Ribble Valley Borough Council
Council Offices
Church Walk,
Clitheroe
Lancashire
BB7 2RA

Phone: 0300 123 6780
Email: Kathryn.Walsh@lancashire.gov.uk
Your ref: 3/2026/0621
Our ref: 3/2026/0621/HDC/KW
Date: 09 September 2026

Location: Kemple Down Birdy Brow Chaigley BB7 3LR
Proposal: Proposed extension and remodelling of existing dwelling including the demolition of the existing self-contained flat and construction of a replacement outbuilding containing garage and garden store.
Grid Ref: 369446 440780

No objection subject to conditions

project	project number	drawing number
Kemple Down	23.61	EX.01
name	existing site plan	
scale	date	status
1 to 200 @ A1	july 2026	planning
		revision
		A

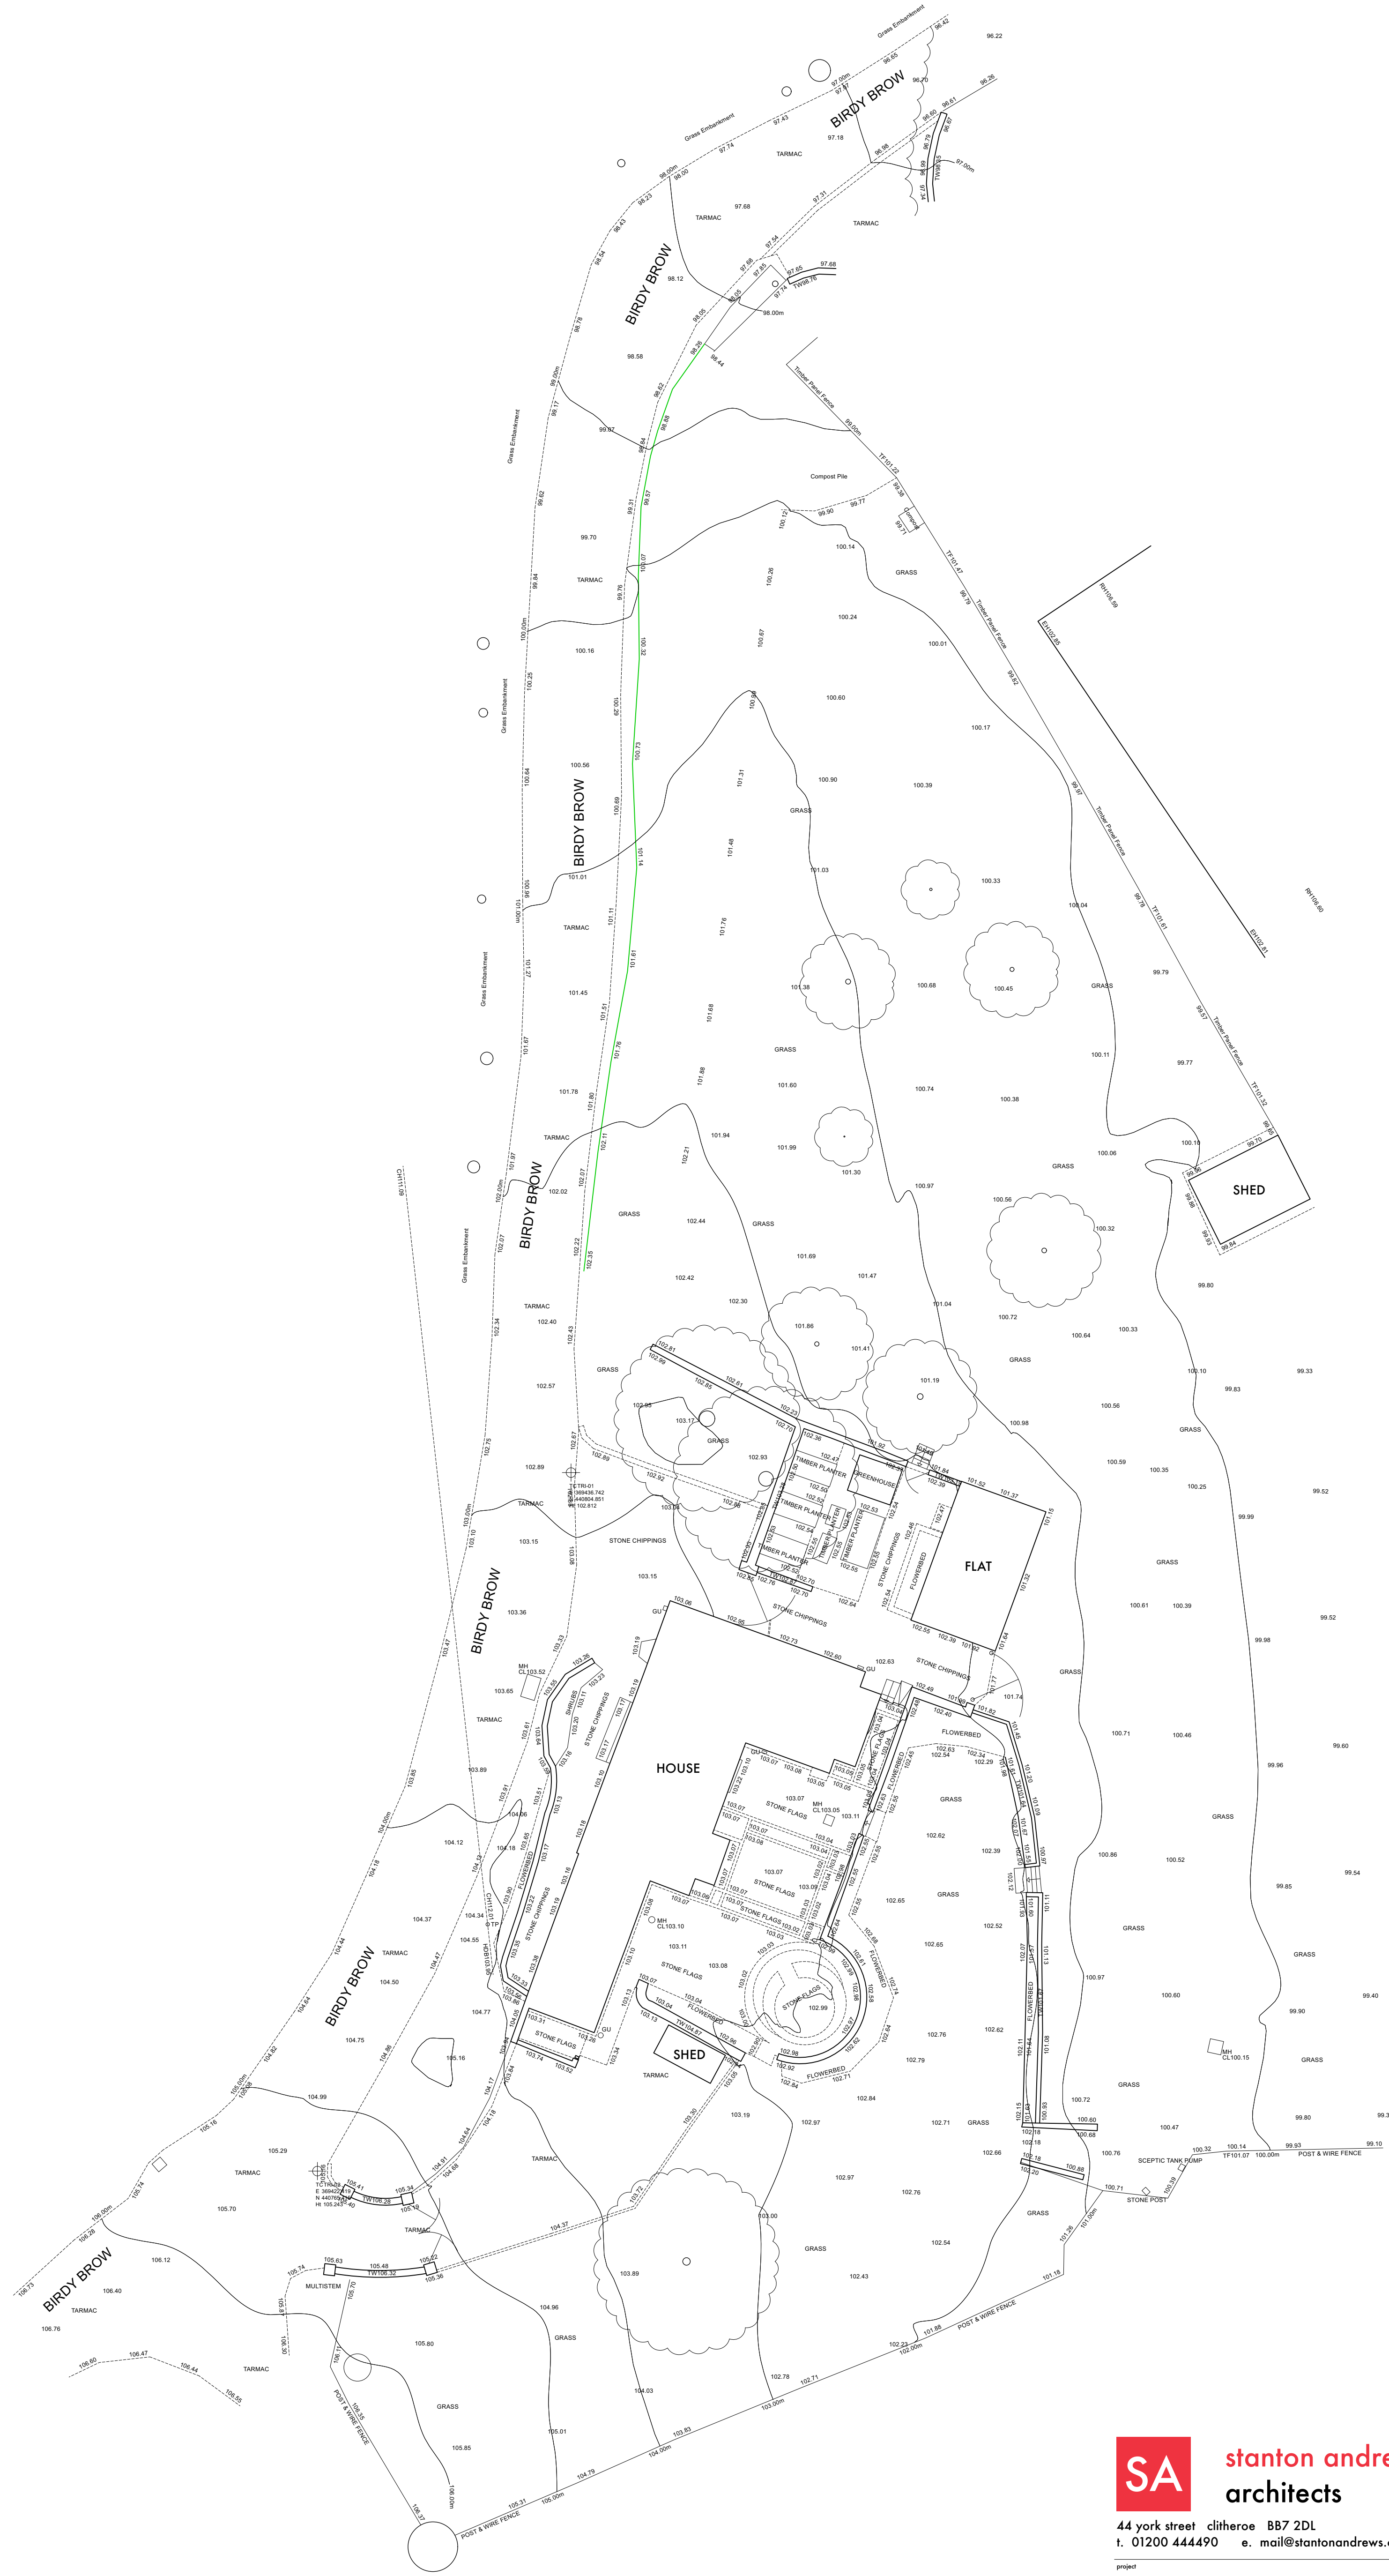
The site currently has two existing accesses as shown on drawing EX.01, Rev A. The application includes the removal of the access which sits to the south and amendments to the northern access. The amendments to the vehicle crossing and reinstatement of the access to the south within the adopted highway will need to be constructed under an appropriate legal agreement with Lancashire County Council.

A Highways Plan
Scale: 1:1250

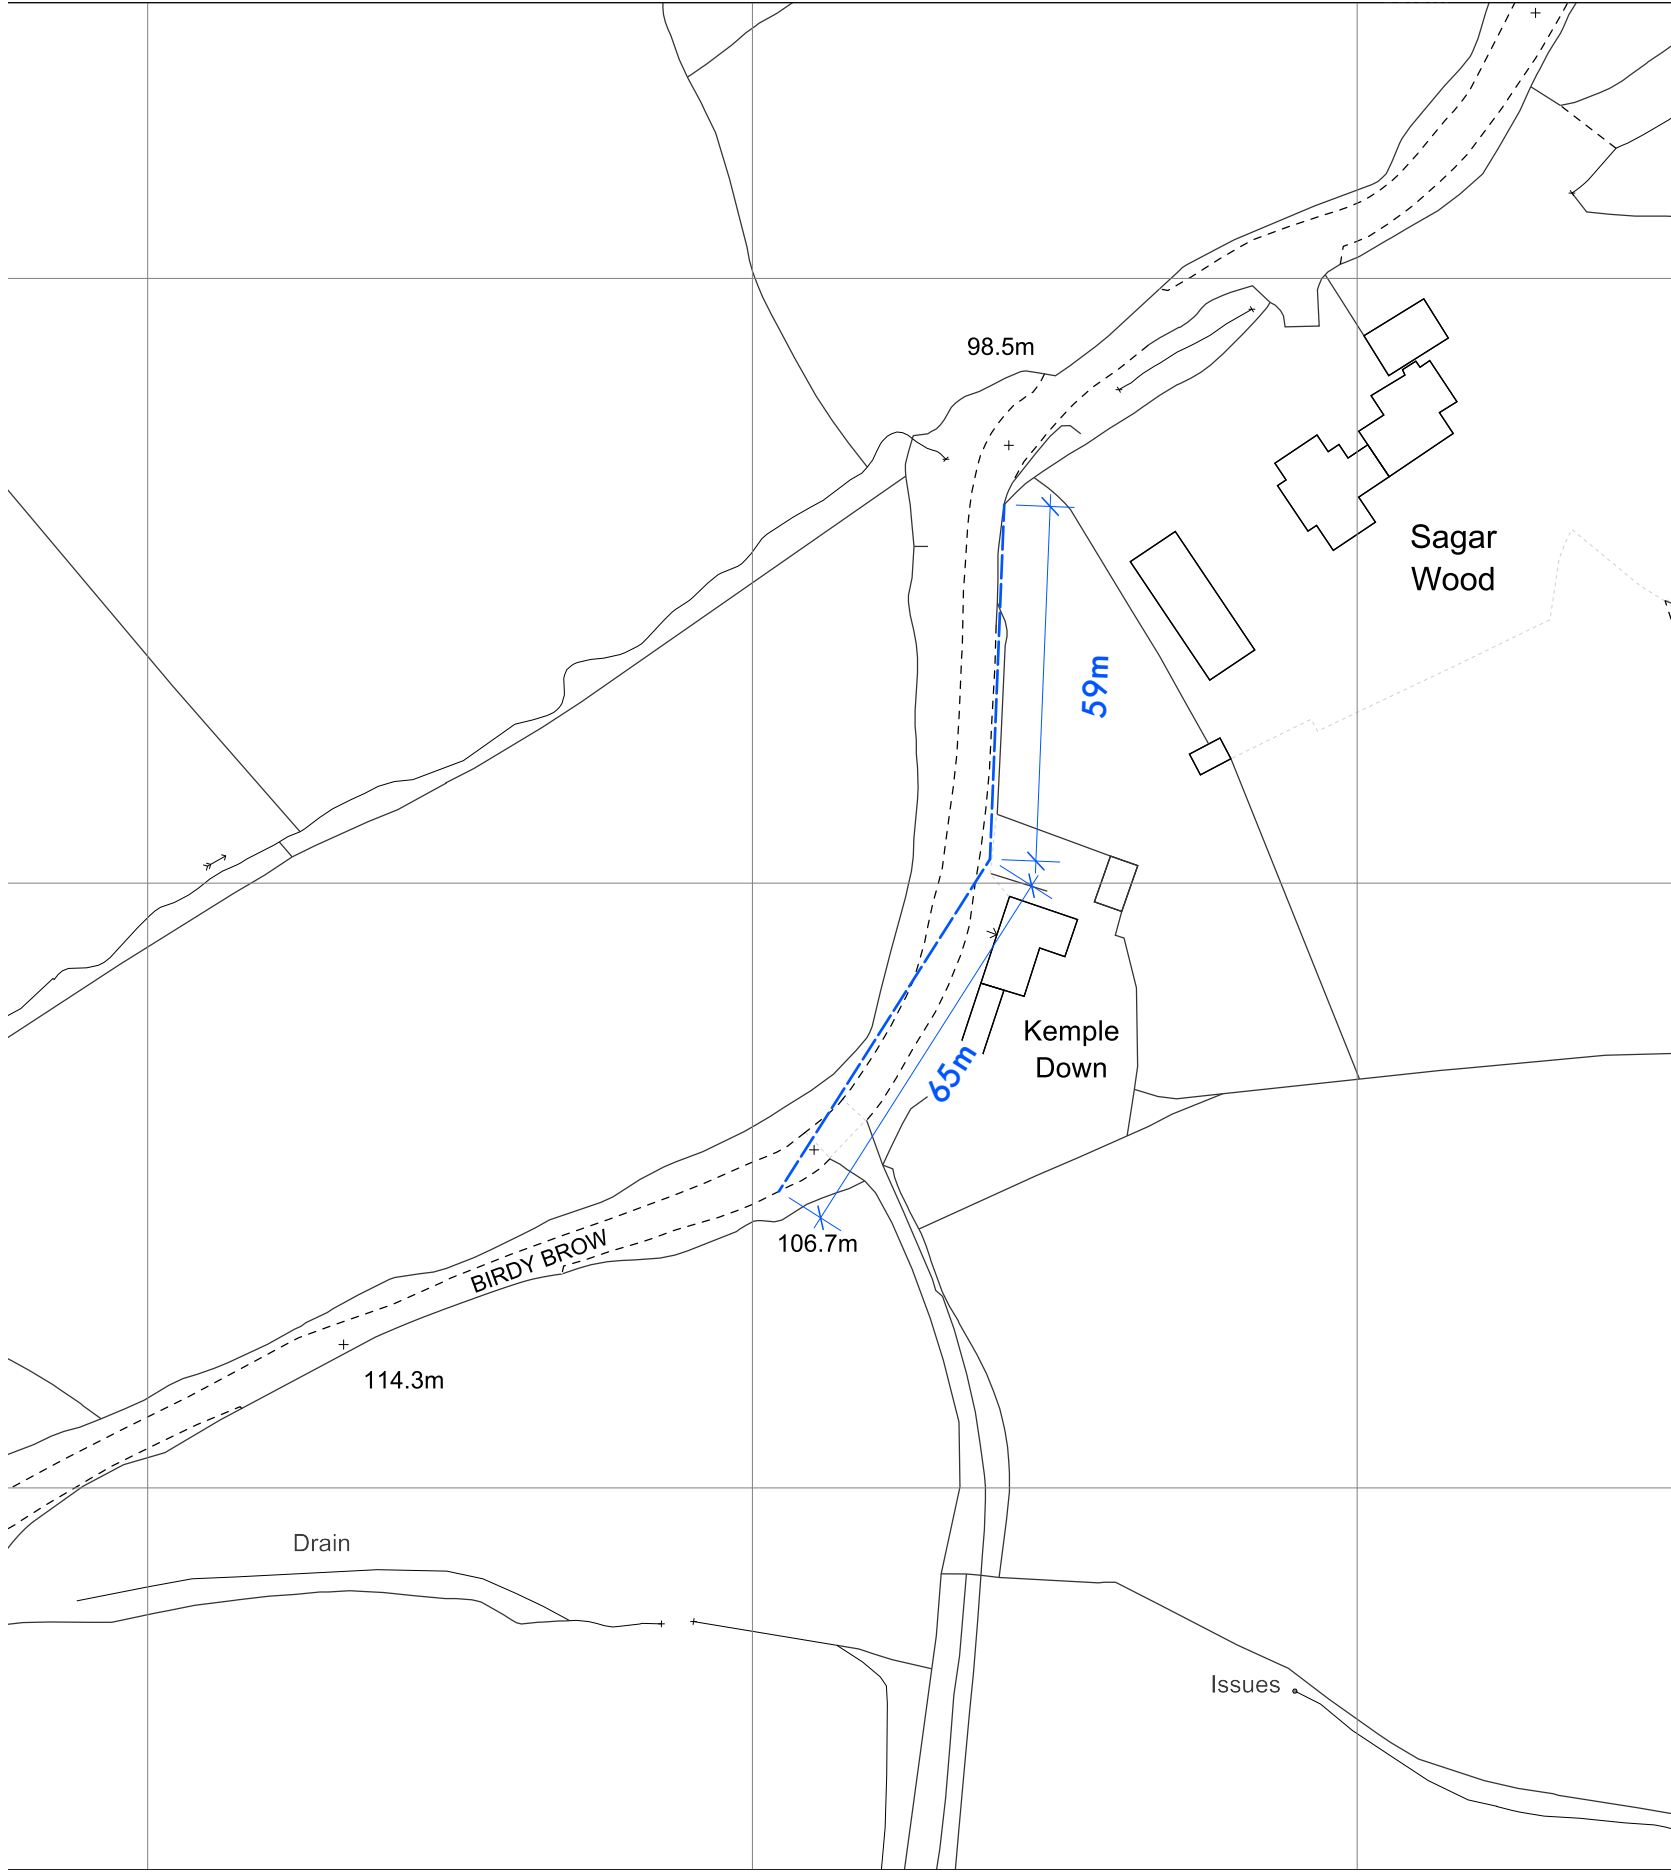
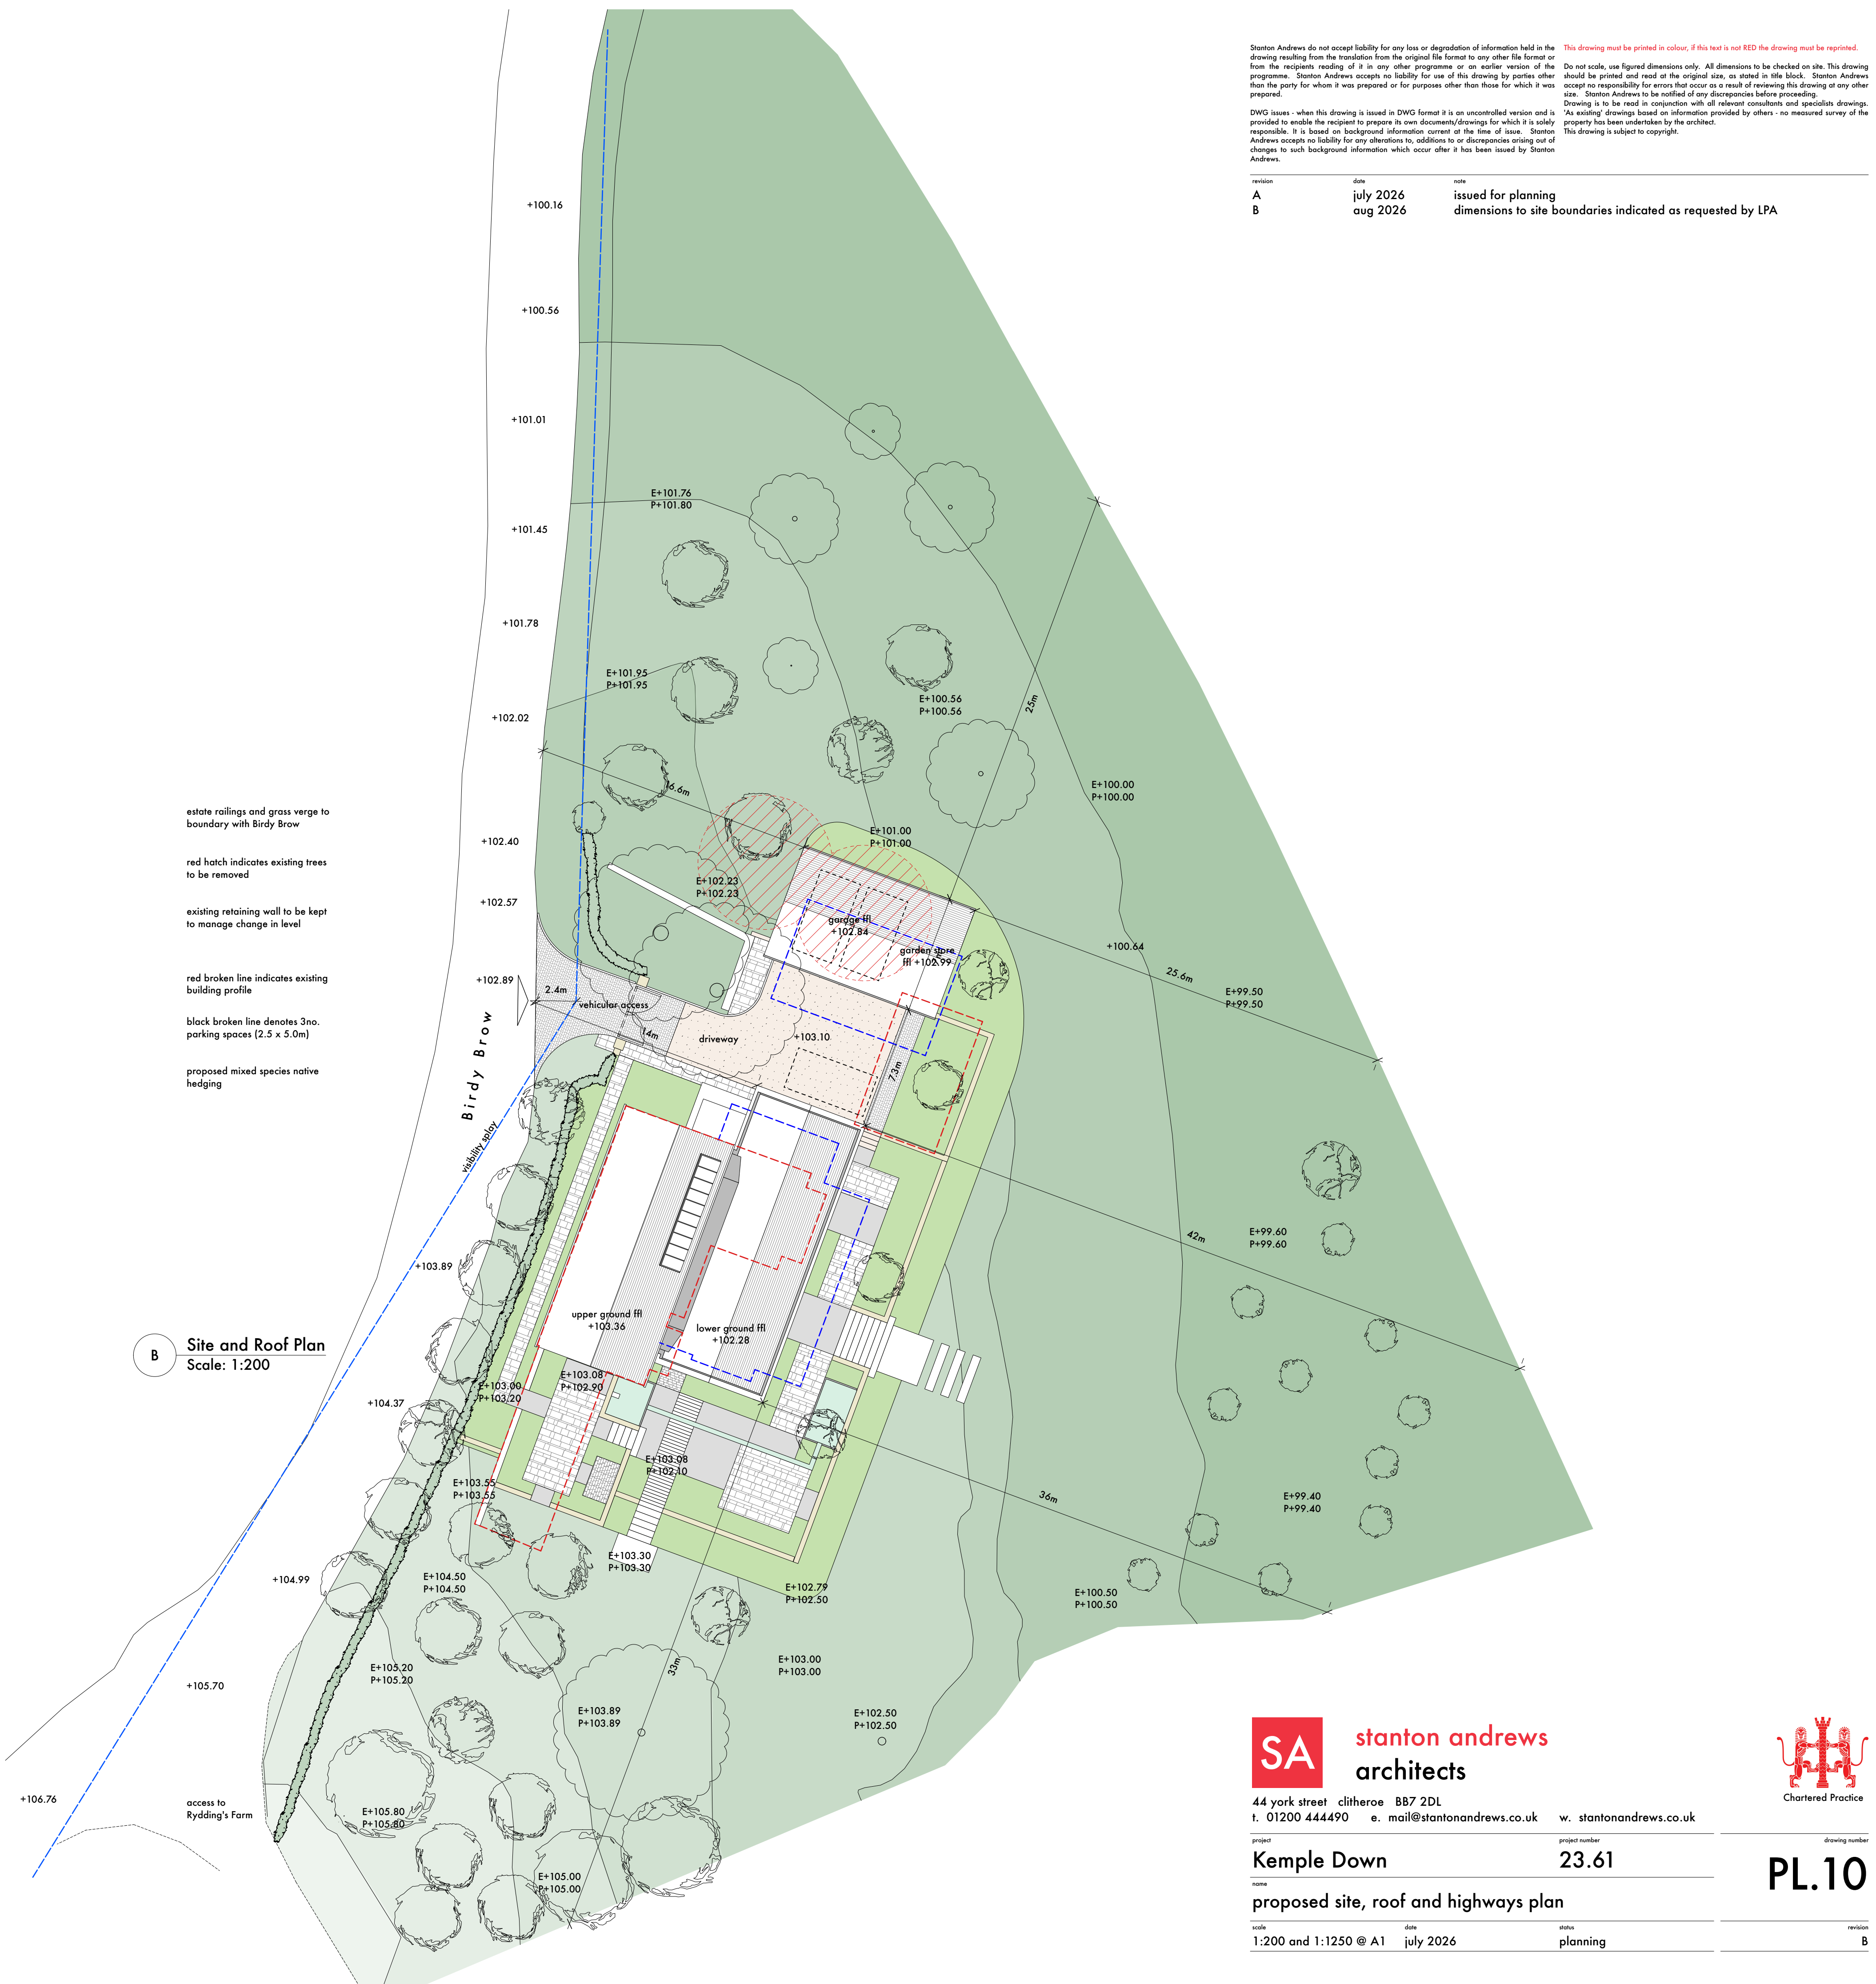
The applicant has also included a visibility splay within drawing number PL.10 Rev B, and whilst this does not meet the posted national speed limit, on-site observations noted lower vehicle speeds given the site's location close to natural bends within the road which contribute to lower speeds along the road. The achievable visibility splays are 59m to the north and 65m to the south. The proposed gate sits at least 5m from the highway edge, allowing vehicles to be clear of the carriageway before the gate is operated.

The access to the north is already used for parking and there have been no Personal Injury Collisions recorded within 500m of the site in the last 5 years, therefore the LHA have no pre-existing highway safety concerns. Therefore, the reduced visibility splay is acceptable in this case.

3. No use hereby permitted shall commence until visibility splay of 2.4 metres back from the centre line of the access and extending 59 metres to the north of the access and 2.4 metres back from the centre line of the access and extending 65 metres to the south of the access along the nearside carriageway edge have been provided, as shown on the approved plans. Nothing shall be erected, retained,

planted and / or allowed to grow at or above a height of 0.9 metres above the nearside carriageway level which would obstruct the visibility splay. The visibility splays shall be maintained free of obstruction at all times thereafter for the lifetime of the development.

4. Before the access is used for vehicular purposes, any gateposts erected at the access shall be positioned 5m behind the nearside edge of the highway. The gates shall open away from the highway.
